Please see attached response to the submissions received on the proposed Belmayne 110 kV Substation in North Dublin City.

**An Coimisiún Pleanála,
64 Marlborough Street,
Dublin 1,
D01 V902.**

**Re: Response to submissions in relation to the proposed development comprising a
110 kV/ 38 MV substation on the R139, Belmayne, Clonshaugh, Dublin 17
ACP Case No. 324276-26**

PE492-D327-006-007

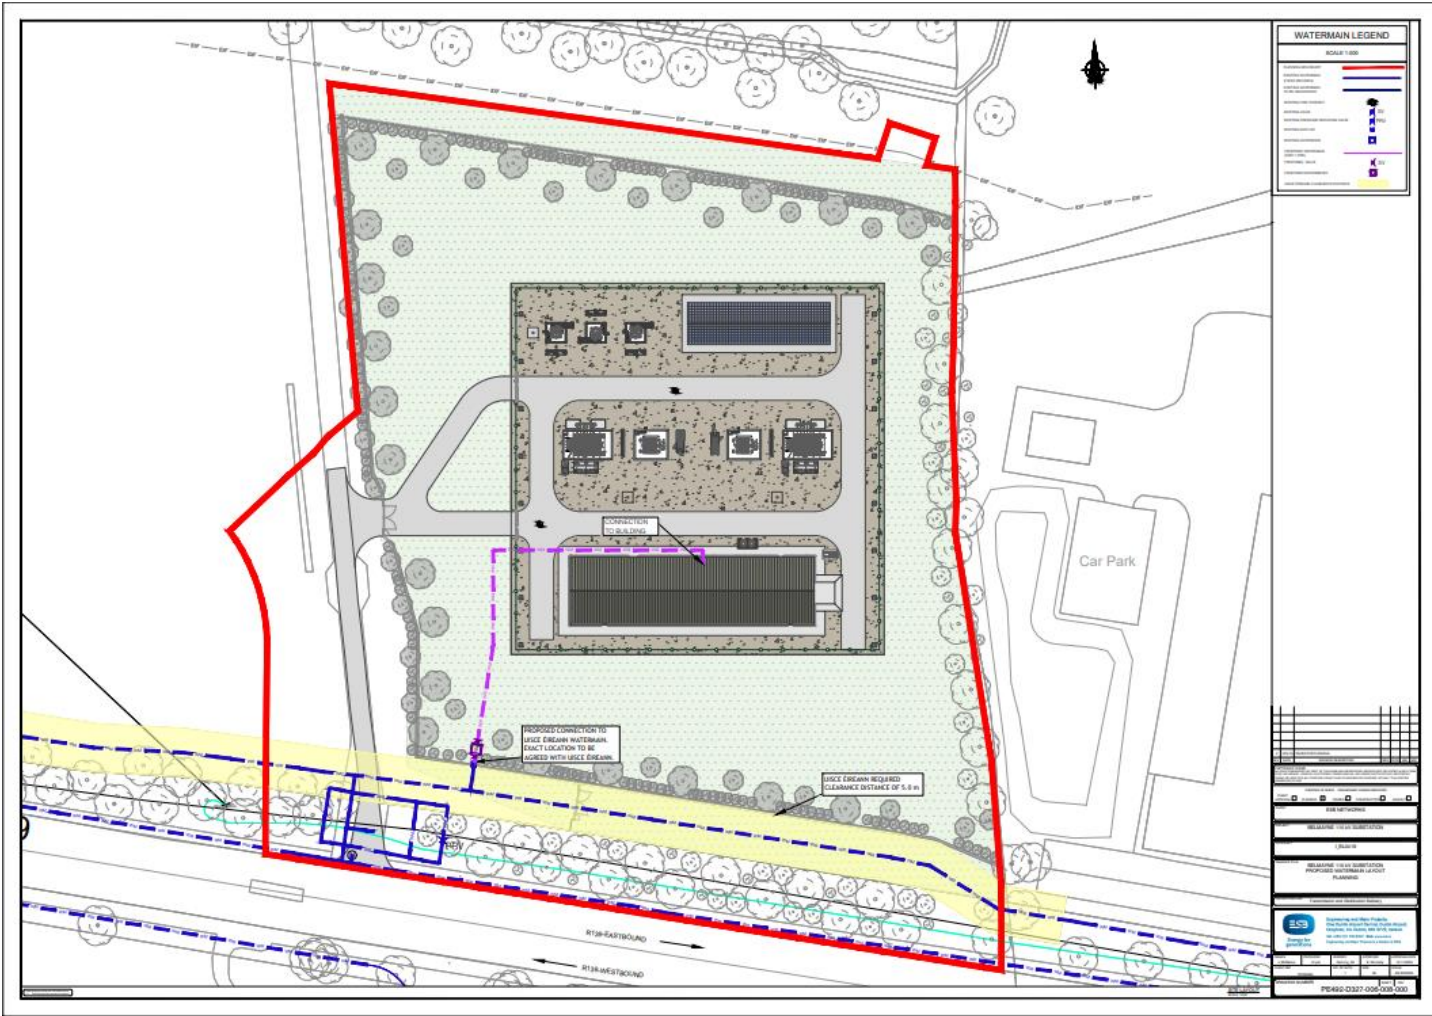
Suggested Condition	ESB Comment
<i>Condition 1 (iv) There shall be provision made for bat boxes and bird nest boxes within the landscape scheme, details to be agreed in writing prior to the commencement of development</i>	Given the electrical nature of the proposed development, the installation of bat or bird nest boxes within or immediately adjacent to the substation compound would not be appropriate. However, ESB is agreeable to the provision of bat and bird nest boxes along the outer perimeter of the development site, particularly within the proposed landscaped areas along the northern and western boundaries. The details of such can be agreed with the planning authority prior to the commencement of the development.
<i>Condition 1(viii) The river corridor lands will be protected from impacts as a result of the development works, except for permitted landscape works in accordance with the agreed landscape scheme. Prior to construction a temporary protection fence with appropriate signage will be erected along the public open space boundary and storage of materials, vehicular access, disposal or dumping of materials/waste/spoil, liquid run-off, soil excavation and vegetation clearance will be prohibited within the protected area. Prior to development the details and alignment of the protection fence will be submitted to the Planning Authority for written agreement.</i>	ESB notes and has no objection to the proposed condition requiring the installation of a temporary protection fence along the northern site boundary, with the final alignment to be agreed with the Planning Authority. As outlined in Section 5.4.1.2 of the AA Screening Report, excavations within 25 m of the watercourse will be limited to the foul sewer connection works and landscaping. All other excavations and all material storage will be set back a minimum of 25 m from the watercourse. This setback allows for interception and management of surface water runoff prior to discharge, thereby reducing the risk of sedimentation entering the river and, downstream, any European sites (SAC/SPA). As shown in the Proposed Drainage Layout (Drwg no. PE492-D327-006-007-001), localised works will be required outside the fenced area to

facilitate connection to the public foul sewer, which is located approximately 15 m from the river. These works will be of short duration, and appropriate control measures will be implemented around this work zone to ensure no surface water runoff enters the river during construction.
<i>Condition (ix) Prior to commencement of development, the developer shall lodge with the planning authority a cash deposit , a bond of an insurance company or such other security as may be accepted by the planning authority to secure the protection of existing trees and hedgerows to be retained</i> <i>Reason: In the interests of protection of biodiversity in amenity, ecology and sustainable development and to secure the retention of existing trees and hedgerows on the site</i>	ESB notes this condition and has no objection to the principle of its inclusion. ESB also wishes to highlight that, following consultation with the adjoining landowner (Glenveagh Homes), it is understood that their proposed development will include the removal of existing trees and hedgerows along the R139, including those forming the southern boundary of the ESB site, to facilitate enhanced pedestrian and cycle connectivity. Accordingly, any bond or security required under this condition should take account of these planned removal works by third parties, and the valuation or extent of security should be aligned with the trees and hedgerows that will actually be retained as part of the final coordinated design.
